CITY OF ALBUQUERQUE

**Re: HB Contractors Grading and Drainage Plan
Engineer's Stamp date 5-15-09 (B18/D015)**

|                            | <b>GRADING AND DRAINAGE PLAN</b>                                                                             | DATE          |

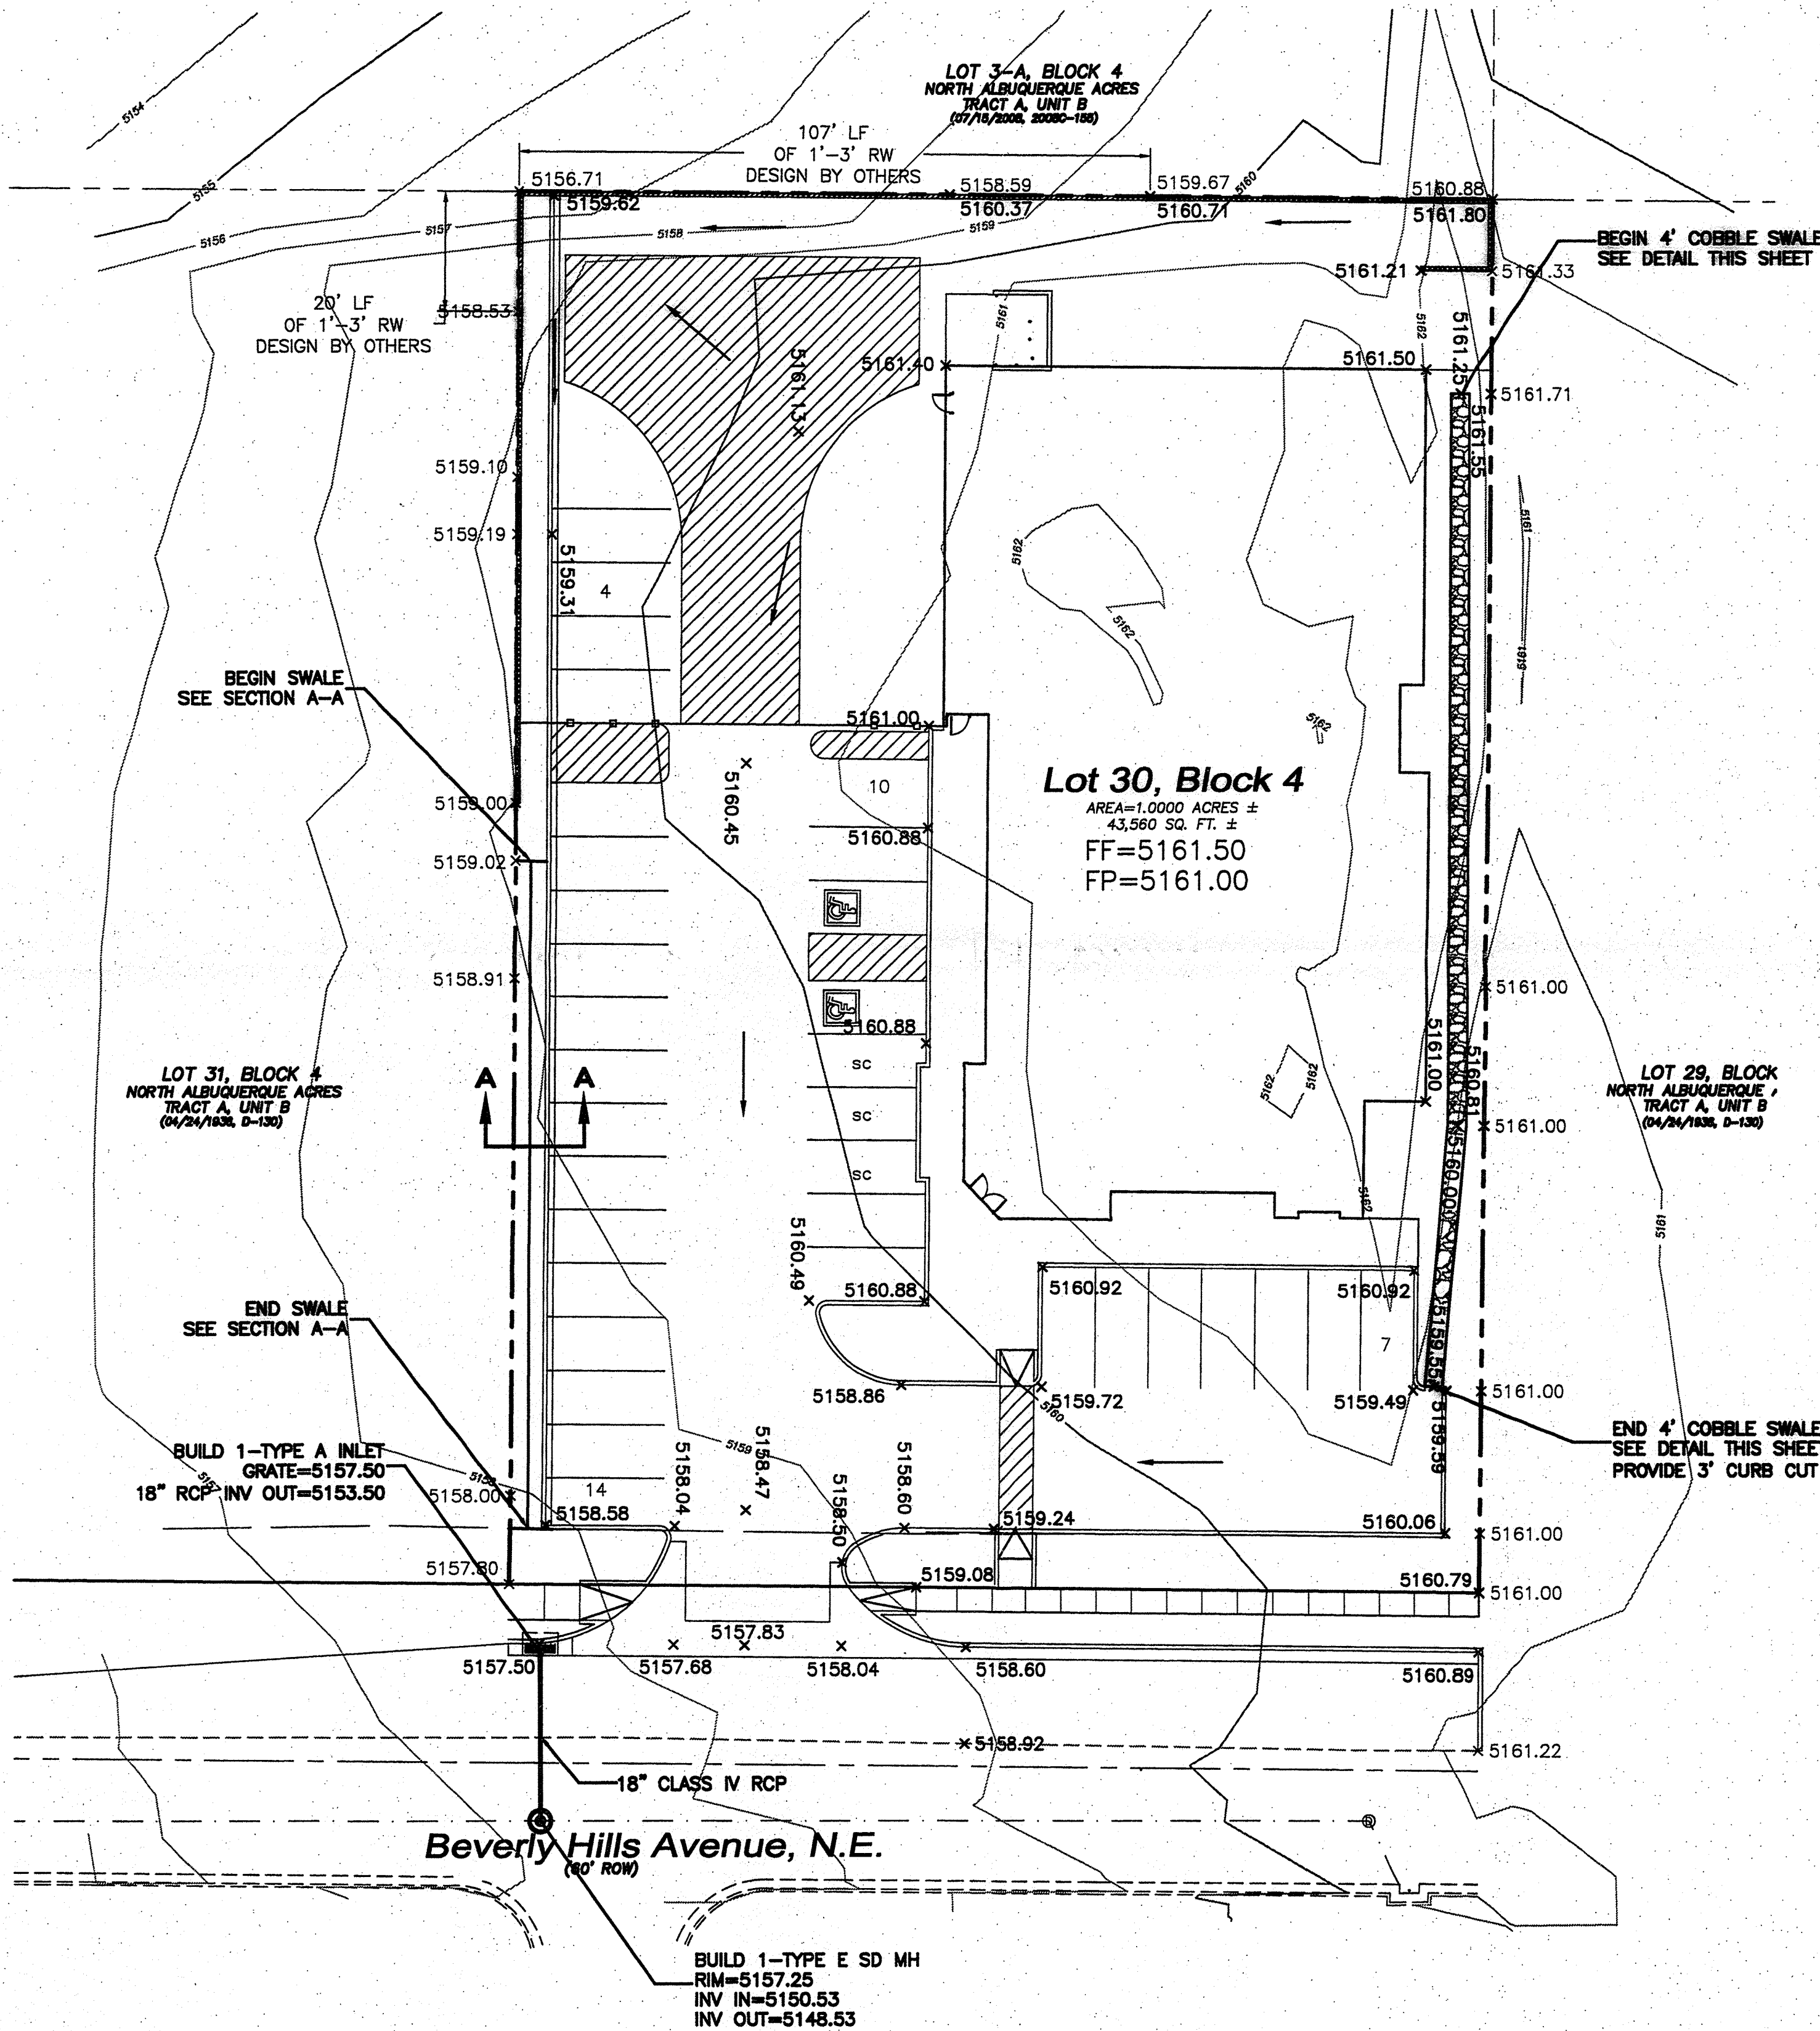
The plan is approvable for Building Permit with minor changes to the grade along the east edge of the site as discussed on 6-3-09. The storm drain work in the City ROW will have to be done with a Work Order.
